**RE: Hacienda HC Expansion
Grading and Drainage Plans
Engineer's Stamp Date: 8/22/22
Hydrology File: L16D043**

Based upon the information provided in your submittal received 9/2/2022, the Grading & Drainage Plan cannot be approved for Building and SO-19 Permit until the following comments are addressed:

C-1

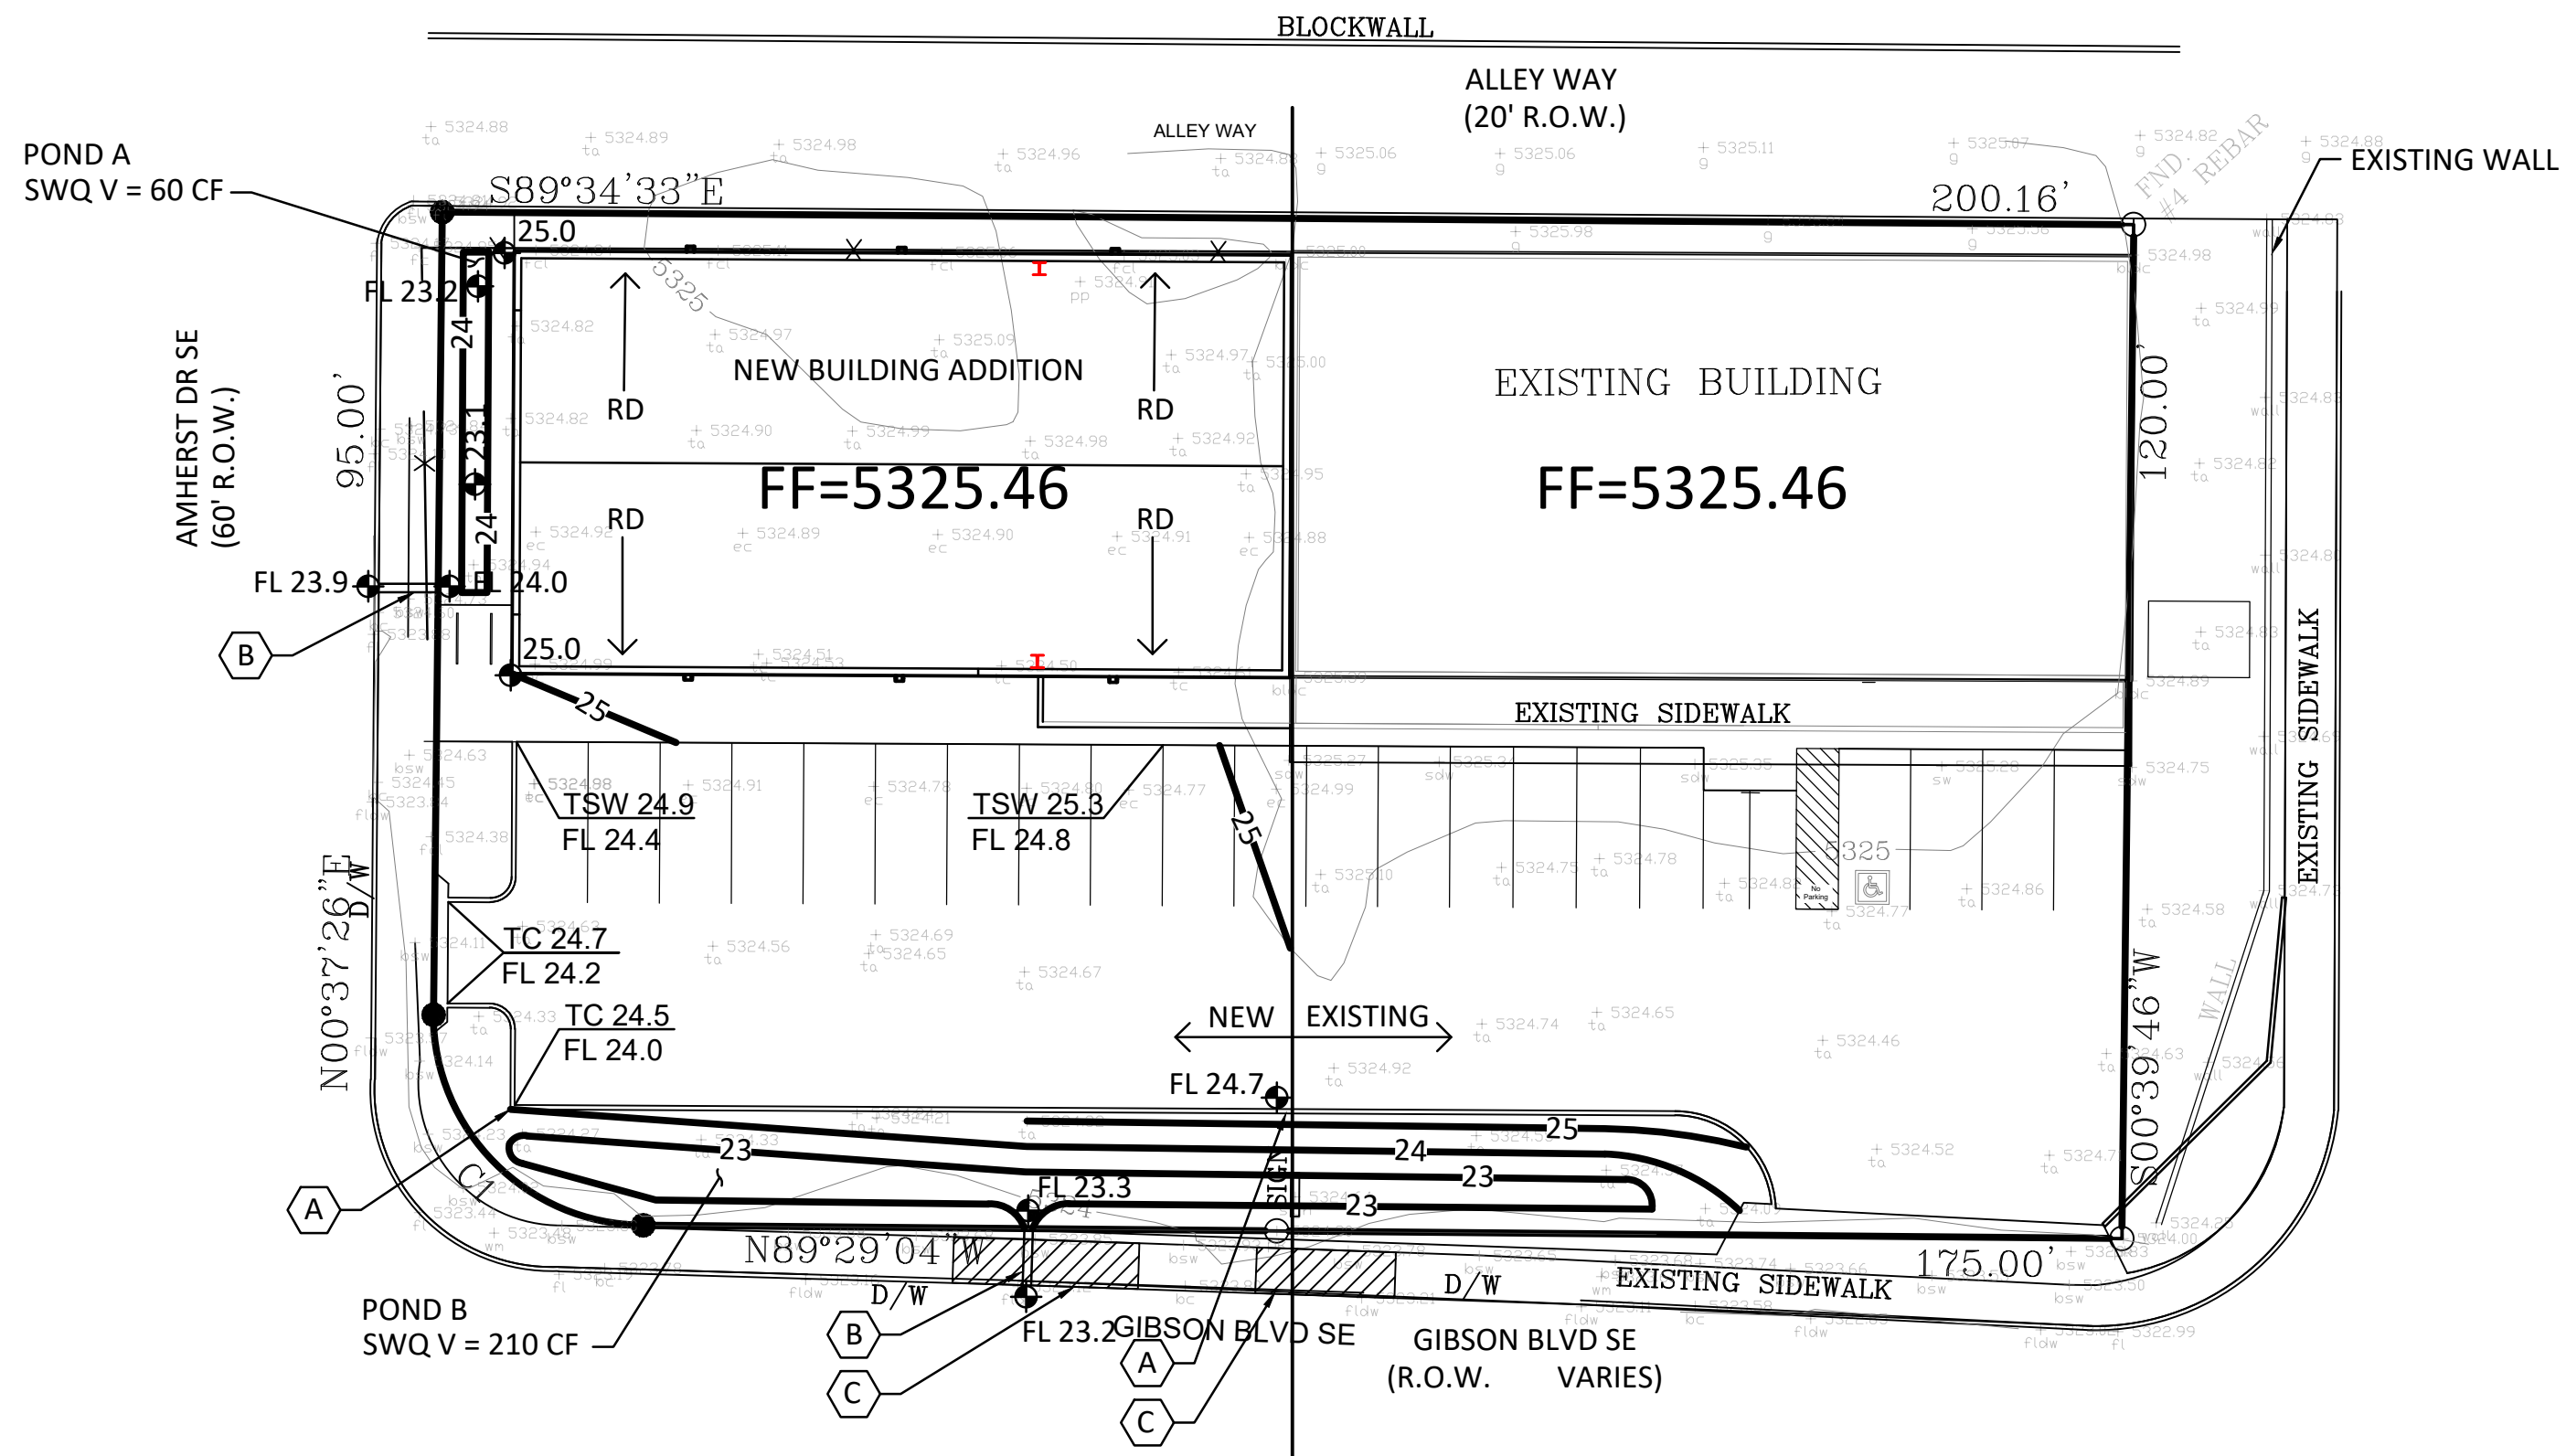
1. The driveway in the middle of the site (near pond) is to be removed and curb and gutter and sidewalk constructed.
2. The proposed "25" contour does not appear to tie to existing grades correctly. It appears it should tie on the east end how you have it, but then cross the sidewalk and wrap around the west side of the building and tie into the "25.0" spot at the northwest corner of the site.
3. There has been change to the inspection group at DMD for sidewalk culverts. Please revise the SO-19 notes to match the notes in the attached pdf.
